RE: Modification to Concept Plan MP06_0171 (Mod 10) and State Significant Development Application (SSD) SSD 14_6673 for Block 4N, Central Park

I write in relation to the Department's email dated 30 March 2015 which referred for our comment a Response to Submissions report for SSD 14_6673. The Block 4N proposal is a residential mixed-use development including hotel and child care.

Reconciliation of Issues

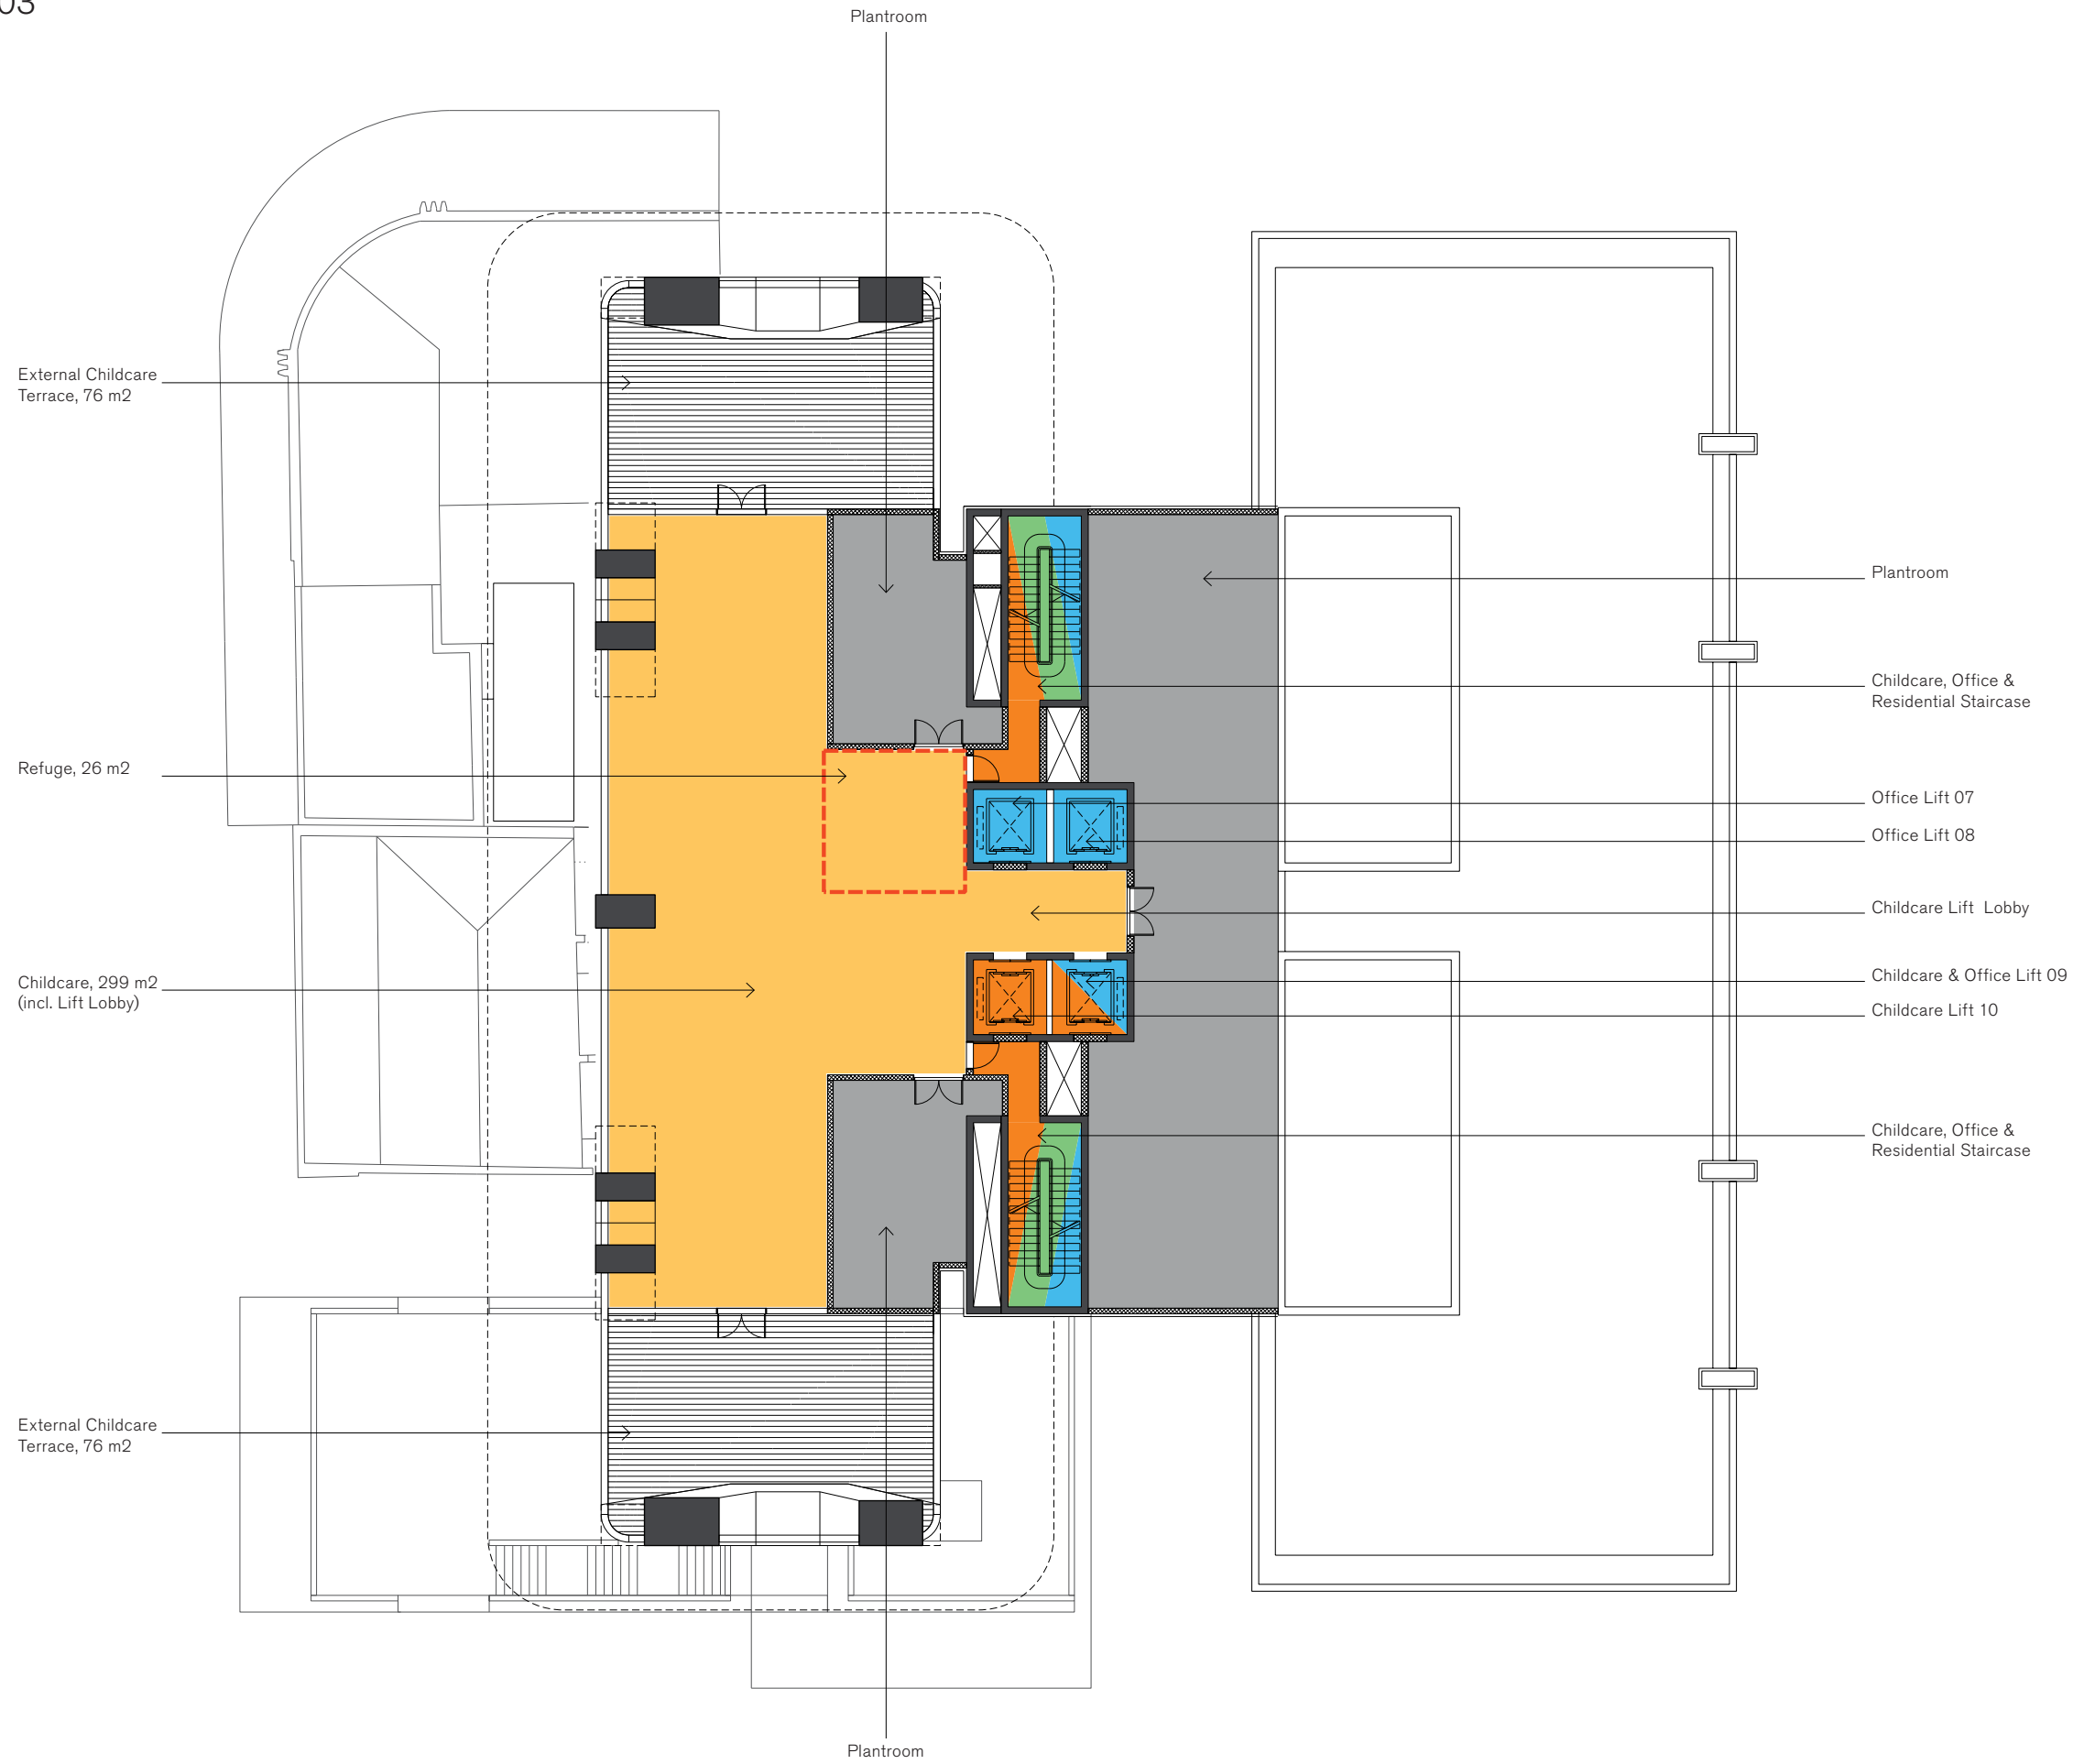
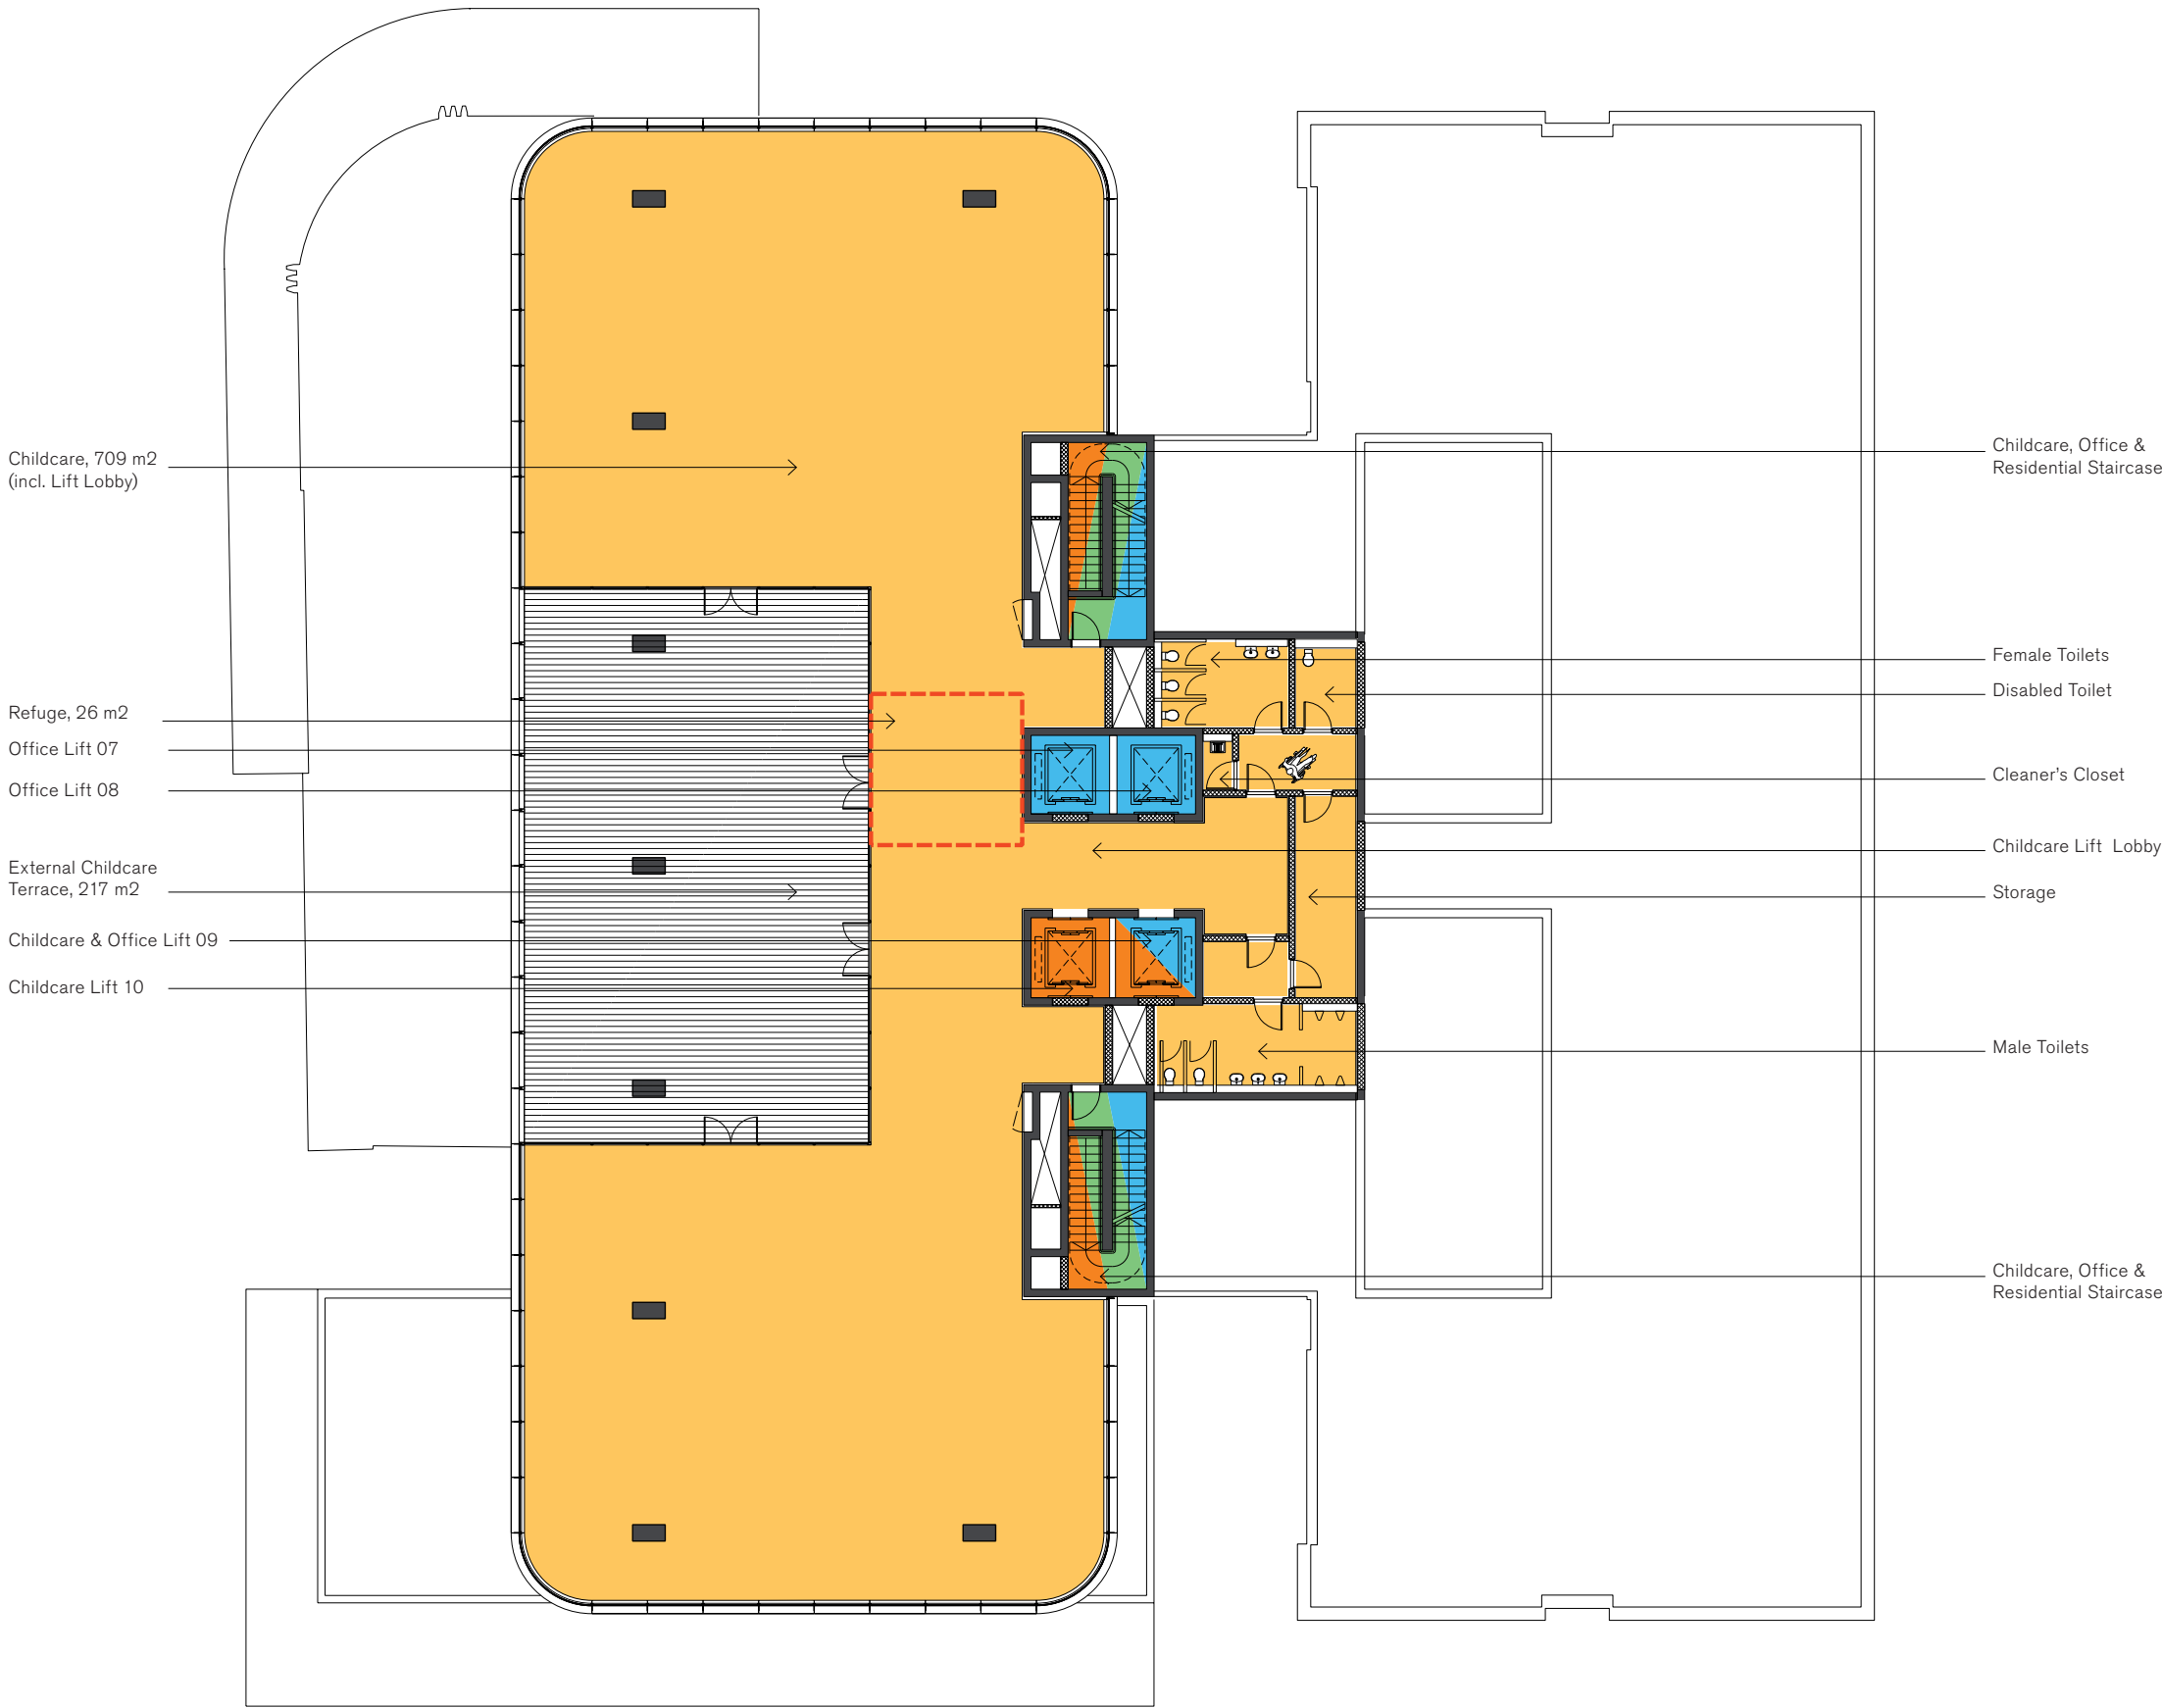
Childcare Centre			
<p>The EIS indicates 1,442m² of floor space to be allocated to the child care centre. However, other parts of the EIS state that 1,080m² will be used by the child care centre.</p> <p>If the intent is to provide 1,080m² floor space, the number of children will need to be decreased. Clarify the maximum floor space provided to the child care centre.</p> <p>For a 90-place child care centre, a minimum of 630m² of unencumbered outdoor play area and minimum of 292m² unencumbered indoor play area is required. If the child care centre is only allocated 1,080m² floor space over the two floors, then the centre must cater for less than 90 children to allow for the inclusion of ancillary play spaces.</p> <p>The plans show a safe haven on each floor. Safe havens must be centrally located within the child care centre and open directly on to a dedicated fire isolated stair. The floor area of each safe haven is to be calculated at 0.25m² per person (per child and per staff member). The plans show a 26m² safe haven on Levels 3 and 4.</p> <p>Investigate opportunities to connect the two floors with internal stairs to allow staff</p>	<p>Two indicative layout options of Level 3 and 4 (future childcare centre levels) were further developed by Future Space in conjunction with Foster + Partners, one of which includes an interconnecting stair.</p> <p>The space allocated for the childcare centre for both Level 3 and 4 combined is a total of 1442sqm (including Unencumbered indoor play space, indoor support space and outdoor areas).</p> <p>Both layouts demonstrate the Child Care levels can cater for 90 children. The installation of the connecting stair would be subject to the child care operator's preferred layout and operational requirements.</p> <p>Foster + Partners and Future Space worked together to develop the options to establish if a 90 children facility is viable and within the proposed base building footprint. The drawings provided demonstrate 90 place child care centre can be accommodated on Level 3 and Level 4 of Block 4N, Central Park.</p> <p>It is further reiterated that the detailed design and layout of the childcare centre is not the subject of this SSDA and will require separate approval by the future operator.</p>	Acceptable	<p>The RTS confirms that there is enough provision for a 90 place child care centre.</p> <p>Of the two options presented, the City's preference is Option 2 which includes the internal stairs.</p> <p>The City notes that a separate DA for the fit-out of the child care centre will be lodged. The plans provided at that stage need to more clearly designate the use of individual rooms to allow an accurate assessment against the required area requirements.</p>
